Consultation Response from: KC Environmental Health (Pollution & Noise Control)		
2021/92233 - Excelsior Works, 35, St John's Road, Huddersfield, HD1 5DX		
Alterations to convert existing warehouse to 5 duplex apartments		
Responding Date: 10 August 2021	Responding Officer: Mohammed Nasim	Responding Ref: WK/202118496
<p><u>Comments</u></p> <p>The applicant has submitted a Supporting Statement from The Architects Bureau. It is undated and unreferenced, but the cover photograph is dated May 2021. Para 5.4 states a noise survey was undertaken in association with the Student Apartment scheme submitted in 2018 and it is proposed to follow the recommendations of that report i.e. all windows will be fitted with glazing of minimum specification 6mm glass x 12mm air gap x 6mm glass and a whole house vent will provide ventilation.</p> <p>In support of the 2018 application under 2018/90108, a Noise Impact Assessment was submitted authored by Acoustic Solutions dated 04 February 2018 Ref 1965-06-18. The objectives for the noise impact assessment were as follows:</p> <ul style="list-style-type: none"> • Establish the ambient and background sound levels at the application site and its surroundin

St John's Road Elevation 1: 100

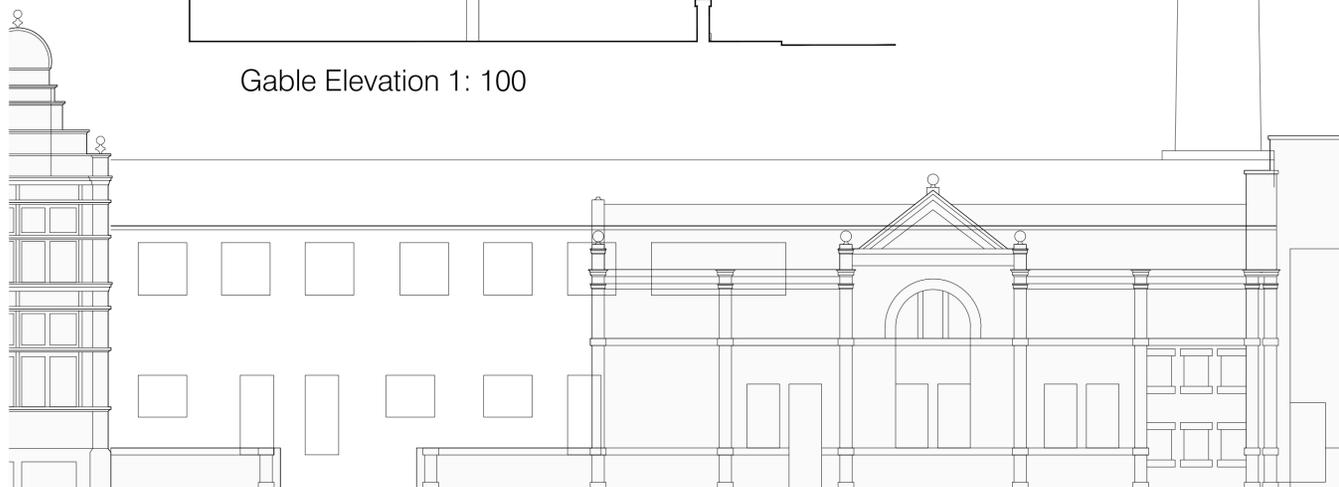
Section 7 recommends all windows to noise-sensitive rooms (living rooms and bedrooms) of the proposed dwellings facing St John's Road to be fitted with glazing of minimum specification 6mm glass x 12mm air-gap x 6mm glass with ventilation provided by acoustic vents. However, should the occupier(s) choose to open the window, then they will be exposed to unacceptable indoor sound levels. Acoustic trickle ventilation alone is unlikely to provide sufficient ventilation to help control thermal comfort without the need to open windows and would therefore not be acceptable and so an alternative ventilation system is necessary.

An alternative ventilation system would need to provide a level of ventilation to properties affected by excessive external noise sufficient to replace the ventilation which would normally be provided by opening windows. During hot weather, the alternative ventilation system must be capable of drawing in cooling external air; any heat exchanges used for warming incoming air during cold weather must therefore be capable of being bypassed during hot weather. Similarly, systems that draw in air from the roof-space of the building would need a bypass to allow air from the outside to be drawn in during warm weather.

Where the alternative ventilation system is mechanical, the self-generated noise created by the system must not cause excessive indoor sound levels. Also, the alternative ventilation system must not compromise the sound insulation properties of the building envelope.

NC7 Ventilation of habitable rooms if windows need to be kept closed - Condition

Before construction commences, a ventilation scheme for rooms where windows need to be kept closed to prevent excessive noise levels shall be submitted to and approved in writing by the Local Planning Authority. The ventilation scheme shall provide the following information -

- Identify which rooms of which plots referenced back to the approved Noise Assessment require a ventilation system
- The acoustic specification of the proposed ventilation system demonstrating that when operated it will not cause indoor noise target levels to be exceeded
- The ventilation Scheme must demonstrate how habitable rooms of these apartments shall be provided with sufficient ventilation to help control thermal comfort and avoid over heating during hot weather without the need to open windows. This should include details of the air intake location and any summer bypass for any heat recovery system including a calculation for air changes/hour. A Standard Assessment Procedure (SAP) assessment would be acceptable to demonstrate that a risk of overheating is minimised.
